**PLANNING APPLICATION CONSULTATION RESPONSE**

<b>Application Number:</b>	3/2022/1158
<b>Proposal:</b>	Erection of 17 dwellings and 57 apartments with associated access, roads, car parking, landscaping and infrastructure, including a public car park to serve Whalley town centre
<b>Location:</b>	Land South of Accrington Road Whalley

ATTENUATION BASIN DETAIL

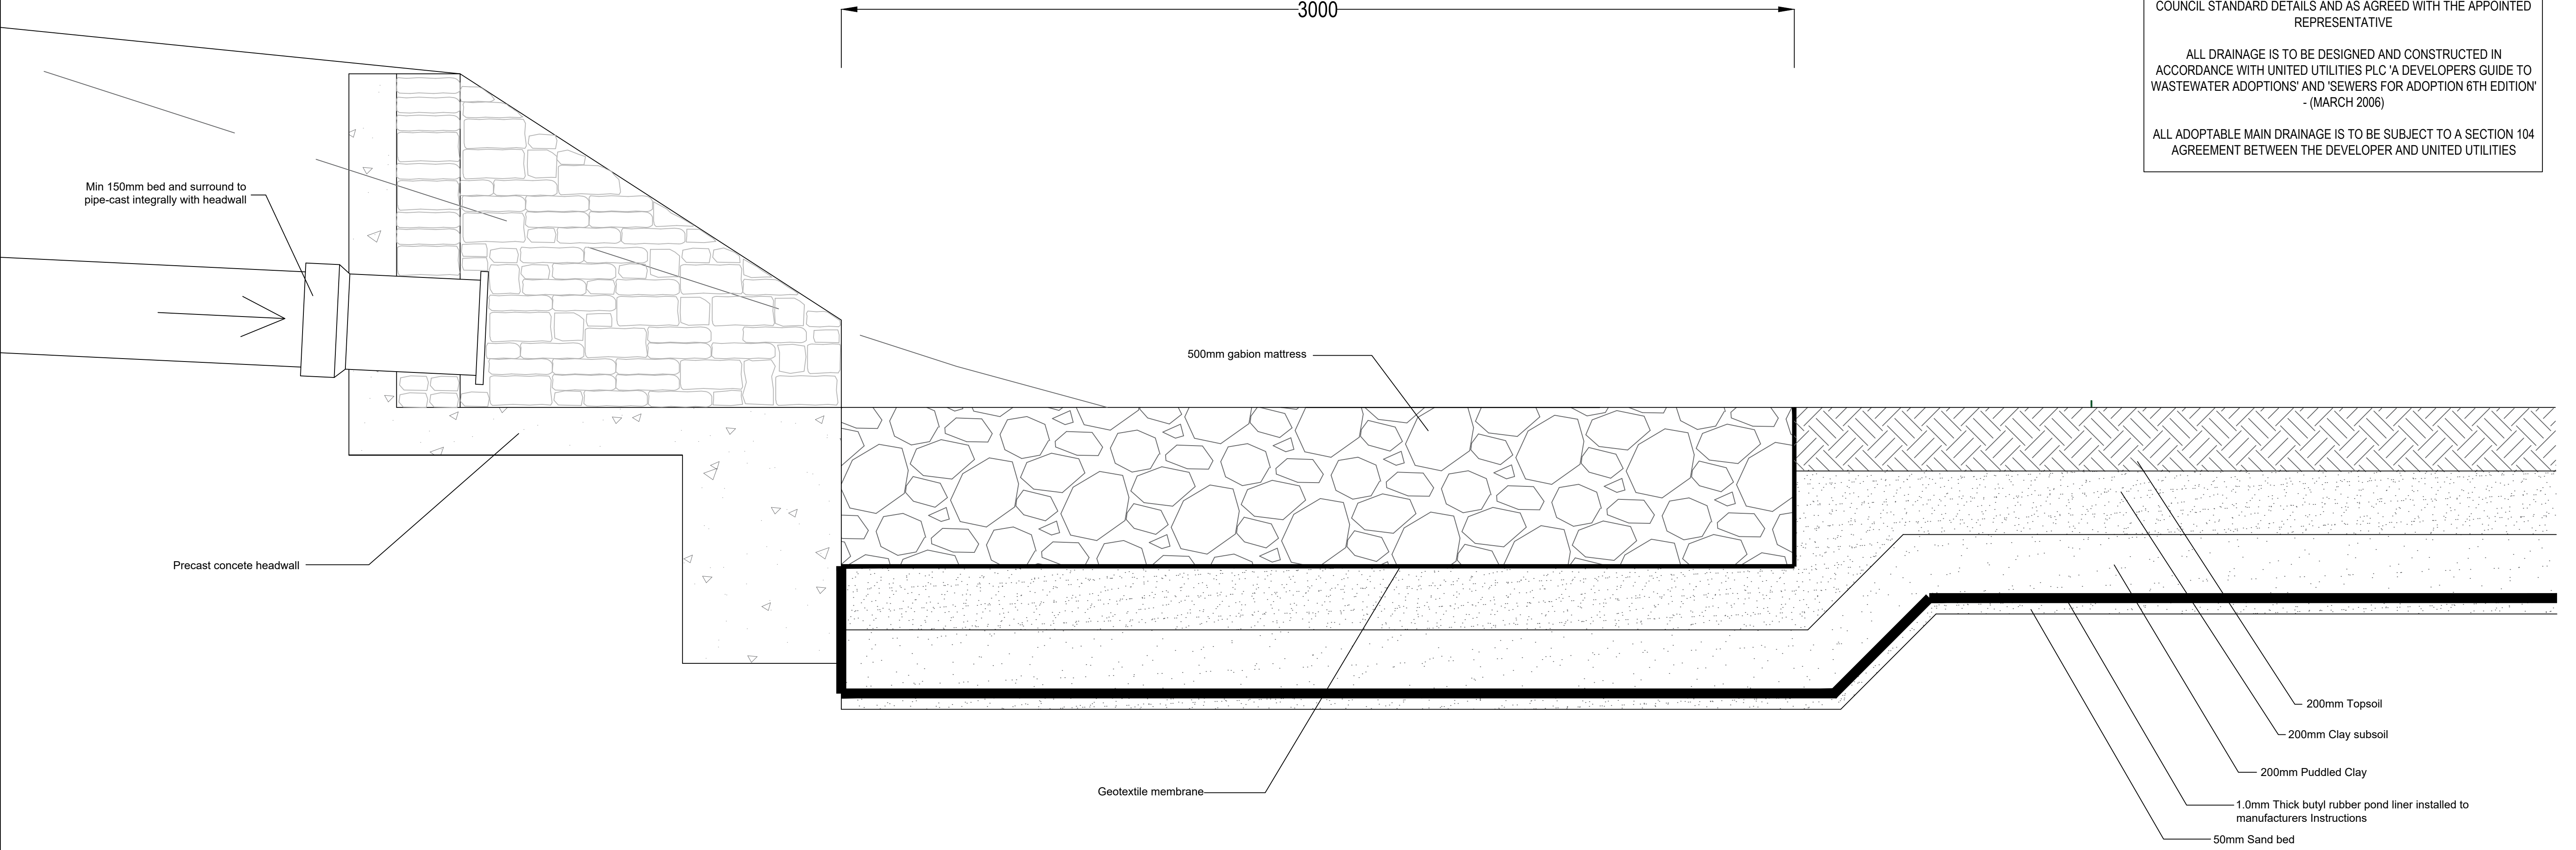
The applicant has included attenuation basins within their sustainable drainage layout. Detailed designs of these must be submitted as part of the final detailed drainage strategy. Historic records of groundwater levels, or ground investigations, should be checked to ensure that during periods of high groundwater, the storage capacity of the basins is retained and that hydraulic connectivity between the surface water runoff and groundwater is acceptable from a water quality perspective. If a liner is used, there is a risk that the liner may 'float' during periods of high groundwater levels. A seasonally high groundwater table may not always impede the proper functioning of the facility, but it can result in a muddy base that may be considered unattractive if not developed into a permeant water feature.
